**KIRKLEES METROPOLITAN COUNCIL
TOWN AND COUNTRY PLANNING ACT 1990
HIGHWAYS DEVELOPMENT CONTROL KP20H**

PLANNING REF 2016/62/92041/E0/AM
CATEGORY Minor

PROPOSAL DEMOLITION OF EXISTING
BUILDINGS AND ERECTION OF
3NO DWELLINGS

LOCATION POPLAR FARM
BRIESTFIELD ROAD
DEWSBURY
WF12 0PA

Drawing Title
Site Plan

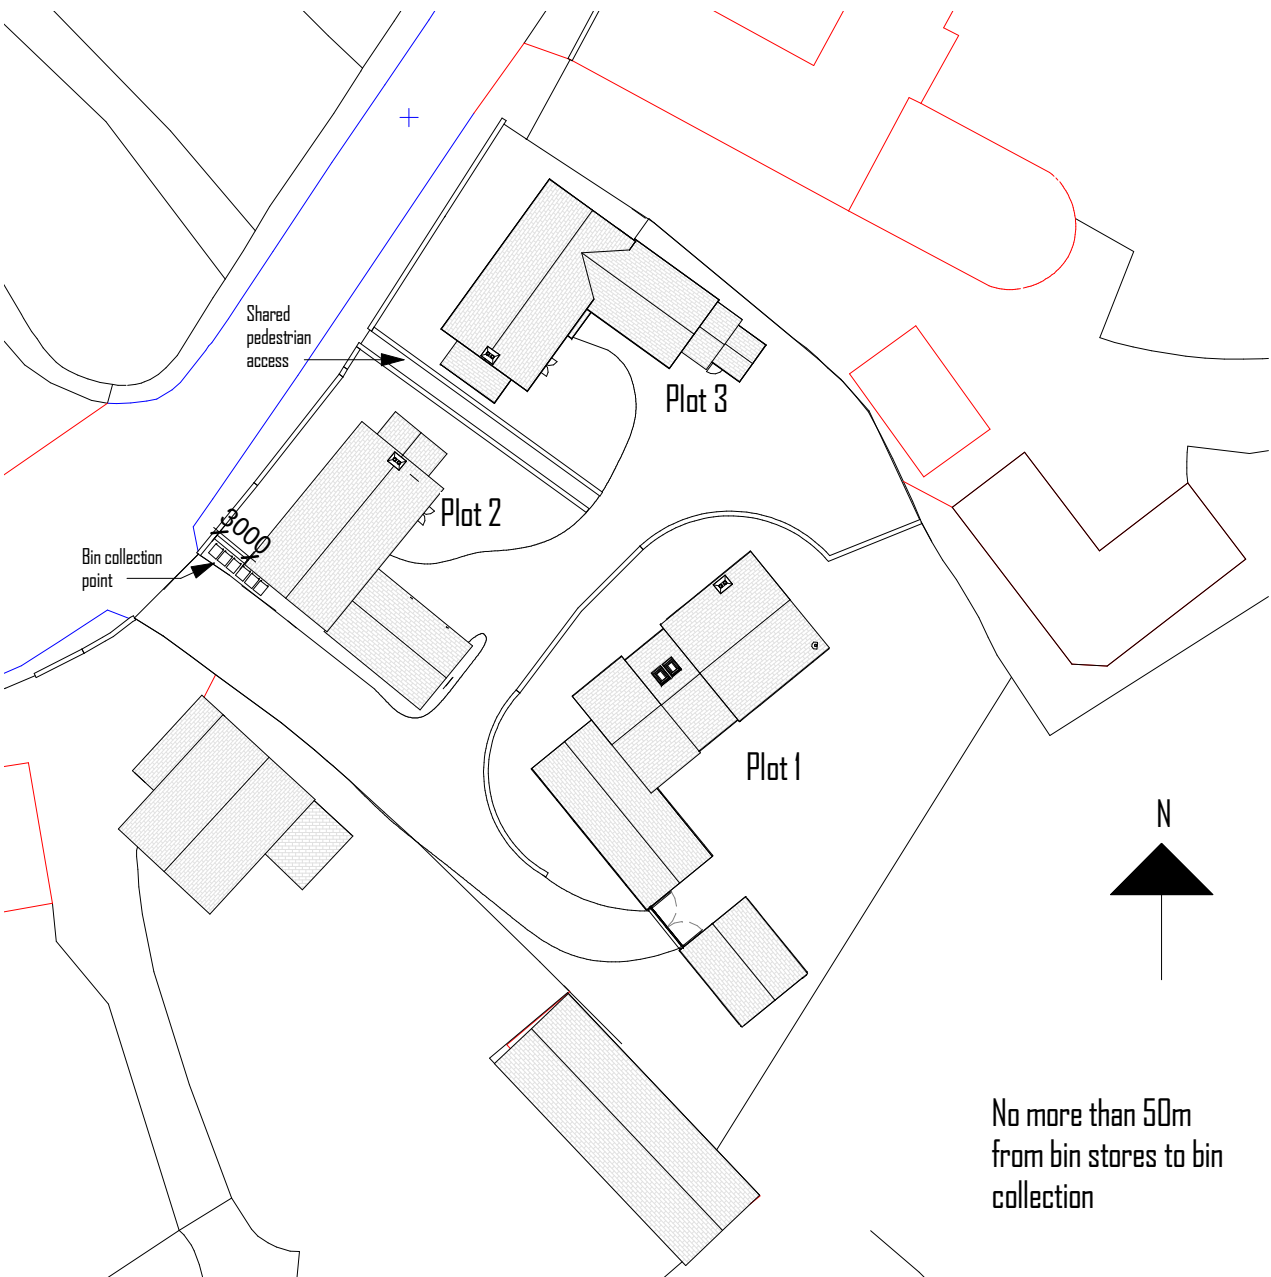
Concern is raised with regards to the lack of adequate turning facility for vehicles on site associated with the south-eastern and north-eastern plots and the impact this will have on vehicular and pedestrian conflict on-site.

Concern exists with regards the length vehicles will have to reverse in order to turn around on-site and access the public highway in a forward gear. Careful consideration should be given to amending the layout in order to provide adequate turning facility and the layout should be supported by swept path analysis demonstrating that the requisite turning manoeuvres can be made in a safe and efficient manner.

It is also unclear as to how refuse collection is due to take place as it is not stated within the submitted Design and Access Statement nor indicated on the submitted plans. Clarification is required in this regard.
